Application for a non-material amendment following a grant of planning permission.

Non material amendment to incorporate bi-fold doors to rear elevation of house types Ennerdale, Thirlmere and Wasdale

DRAWING NUMBER
016/ENN/P02

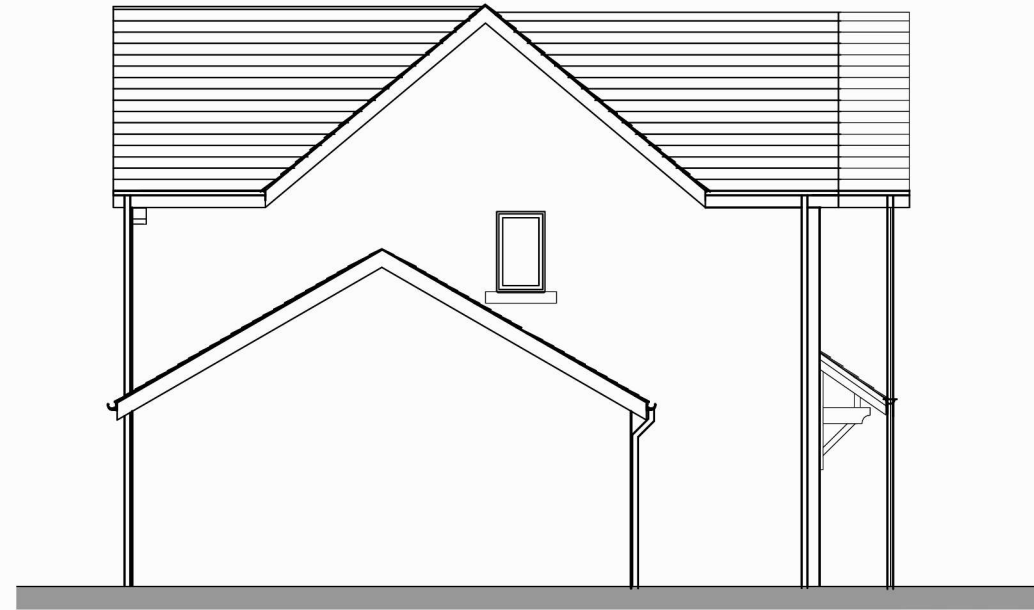
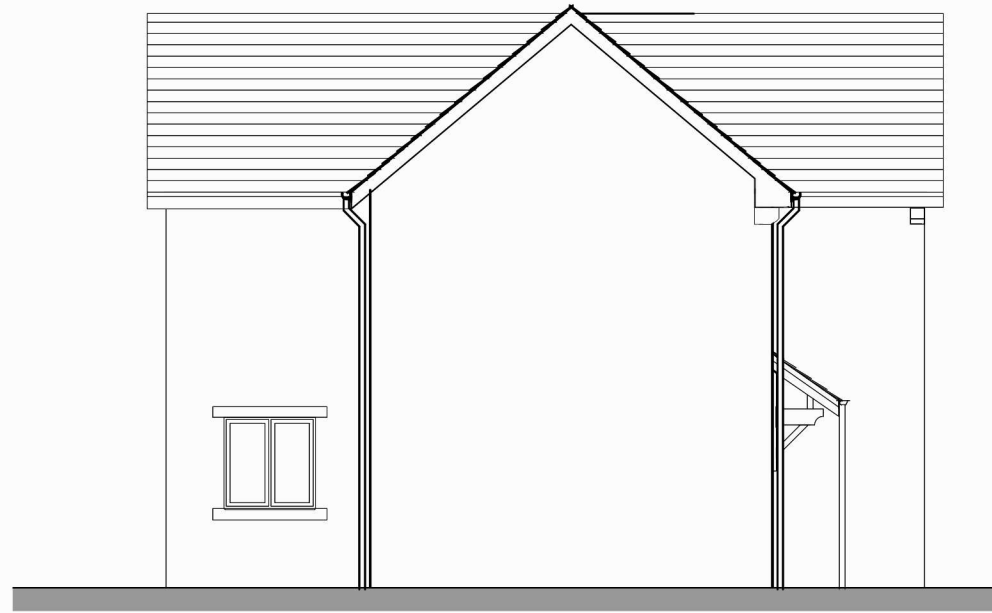
To incorporate bi-fold doors in-lieu of French doors currently approved
